## **FIRE RISK MANAGEMENT, INC**

# **Memo Report**

**Subject: Fire Protection & Life Safety Code Review; ICW Design Plans for the Addition to the Bayside Bowl Facility in Portland, ME**

SHEET TITLE:
FIRST FLOOR PLAN

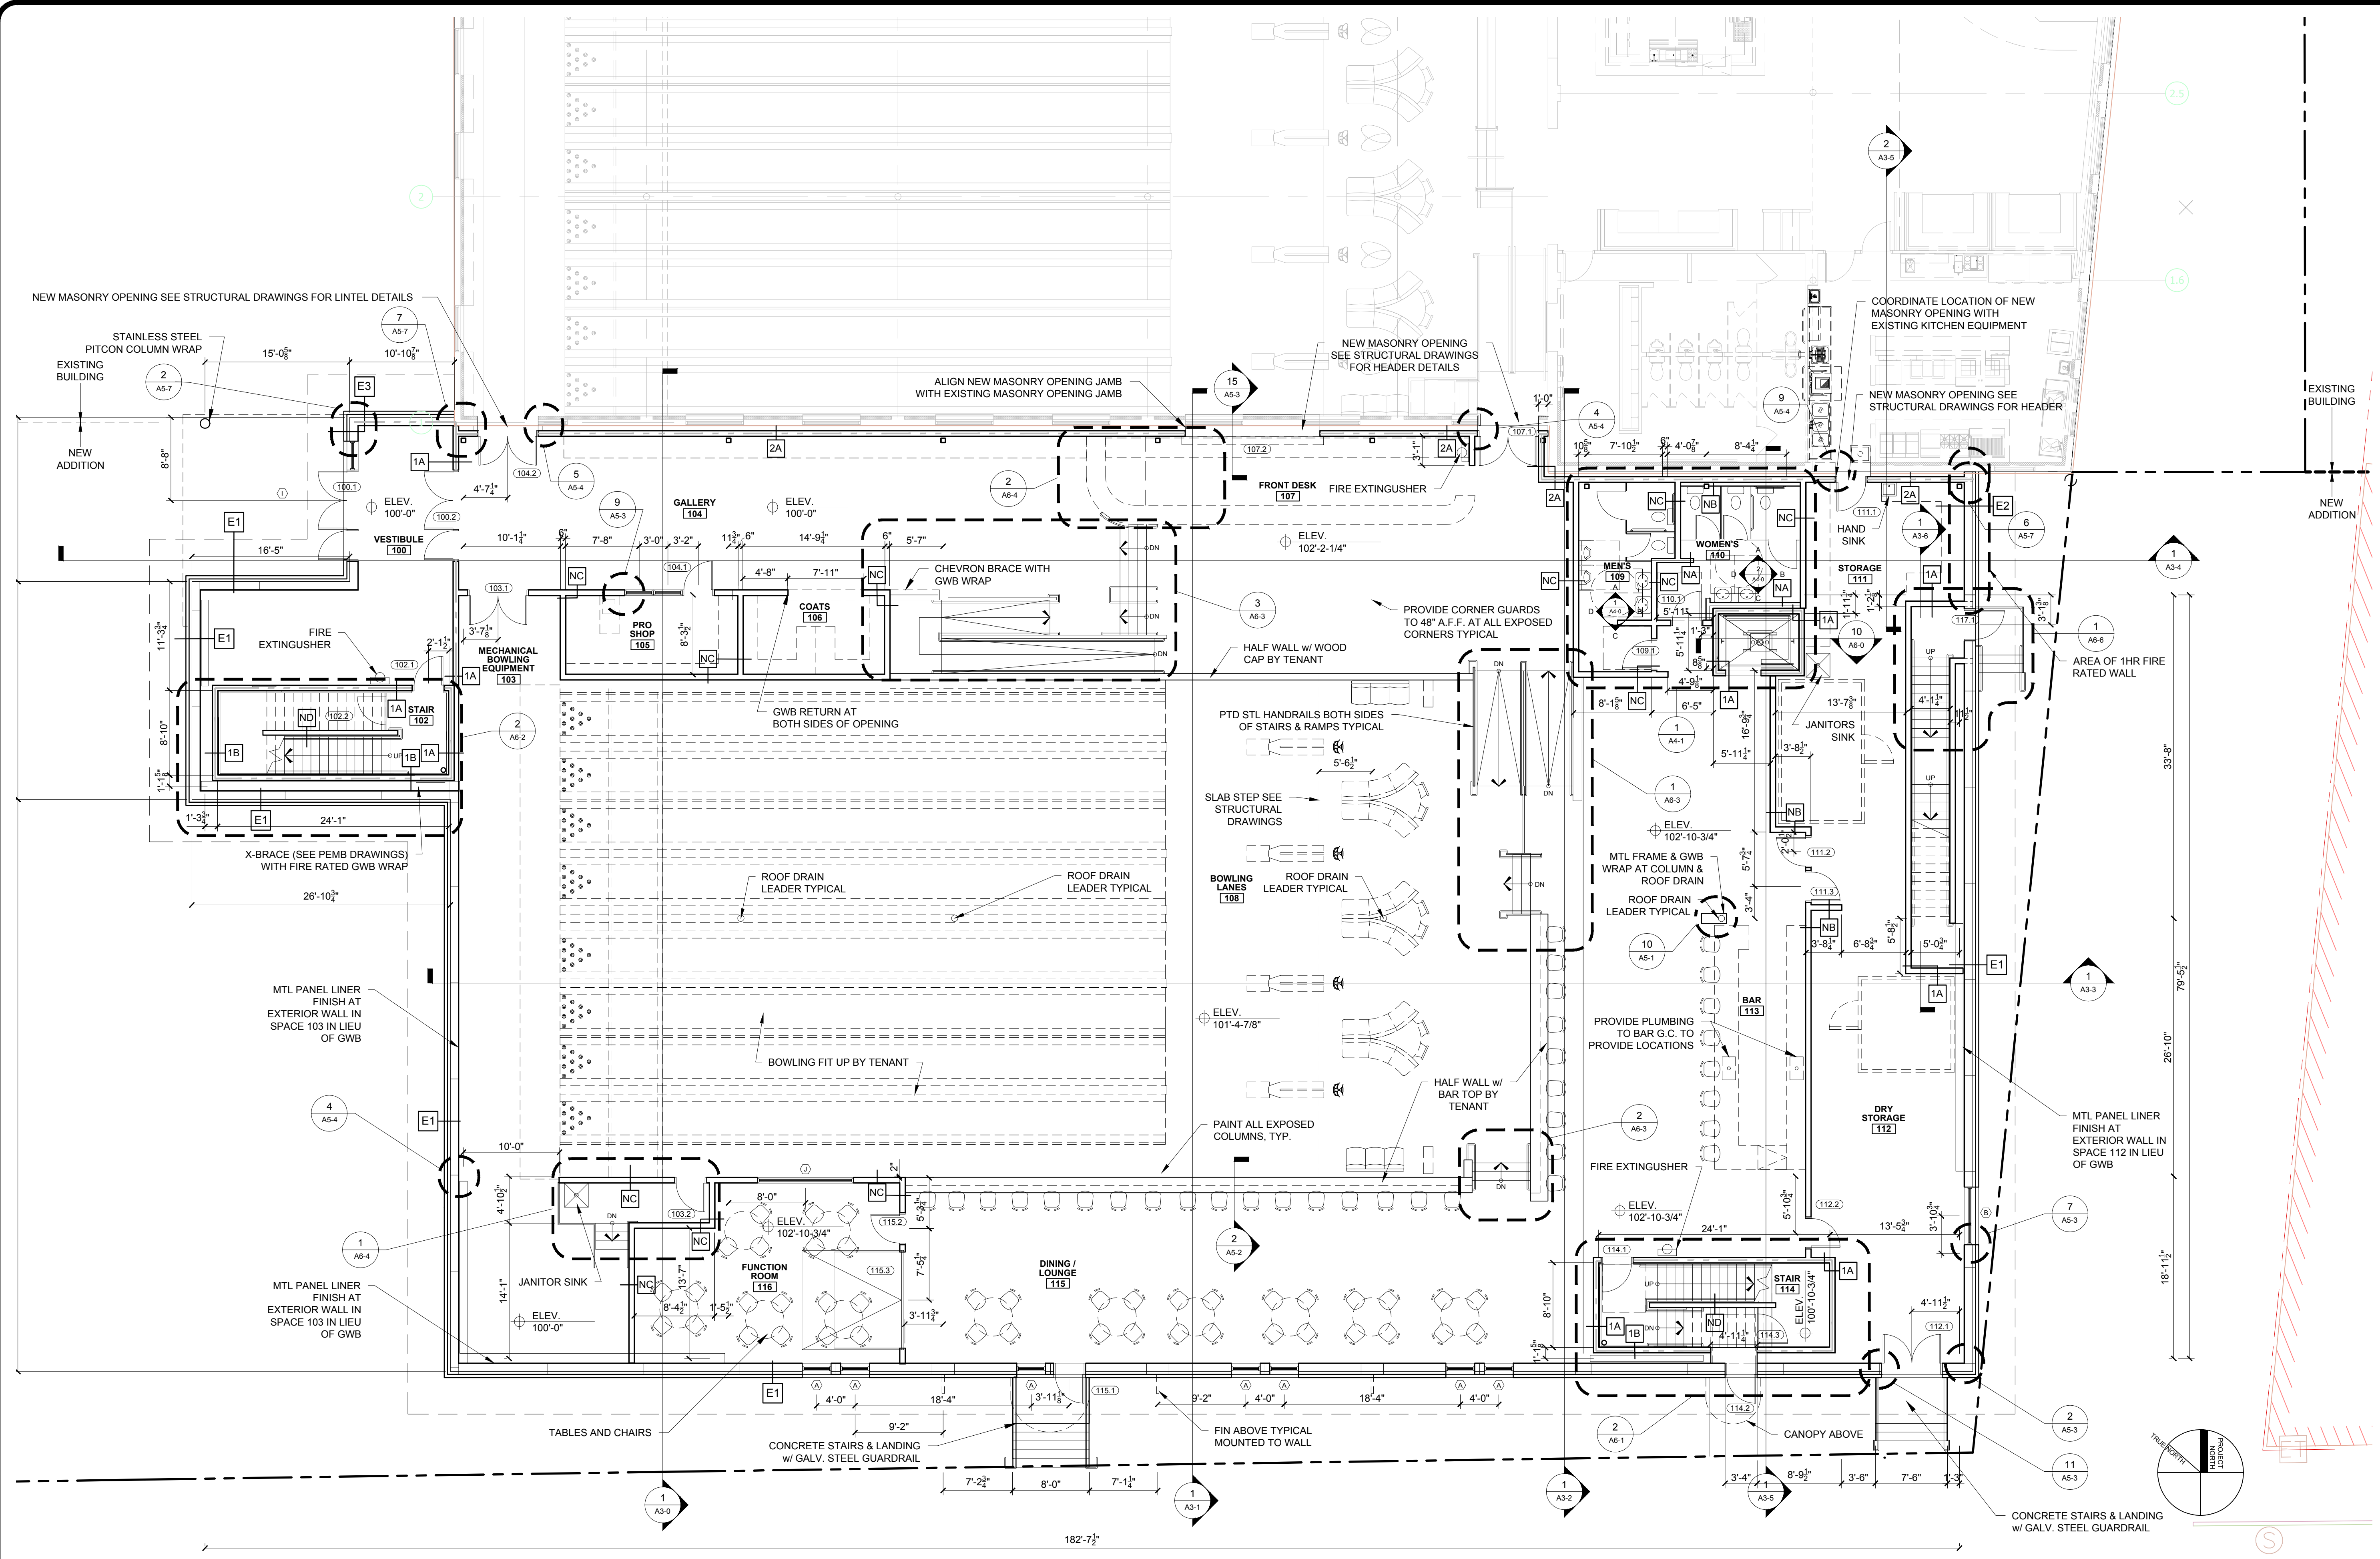
The design documents that were initially used to support this review were those provided by Senator Architecture that were listed as a “Progress” set with a date of 12 January, 2016. However, some additional floor plan changes resulted during the review and the updated plans reflected a date of 29 January, 2016. In addition to the general site requirements, the architectural floor plans and details included with the progress set provided data regarding the overall dimensions of the building, along with its general layout and the planned fire separation for the various areas/occupancies within the building.

In general, based on the updated set of plans that were provided, the building addition appears to meet all applicable code requirements. A sufficient capacity for the means of egress components exists throughout all areas of the new addition, including the doorway(s) that will act as the building’s main entrance. The proposed design for the new main entrance will easily accommodate at least 50% of the building’s occupants as required by NFPA 101 for an Assembly occupancy of this type. Both the mezzanine and roof deck areas are served by two separate and properly fire-rated exit stair enclosures, along with having access to the elevator. All

travel distances, including common path of travel, to an approved exit appear to be compliant with the requirements outlined by NFPA 101, Chapter 12 – *New Assembly Occupancies*.
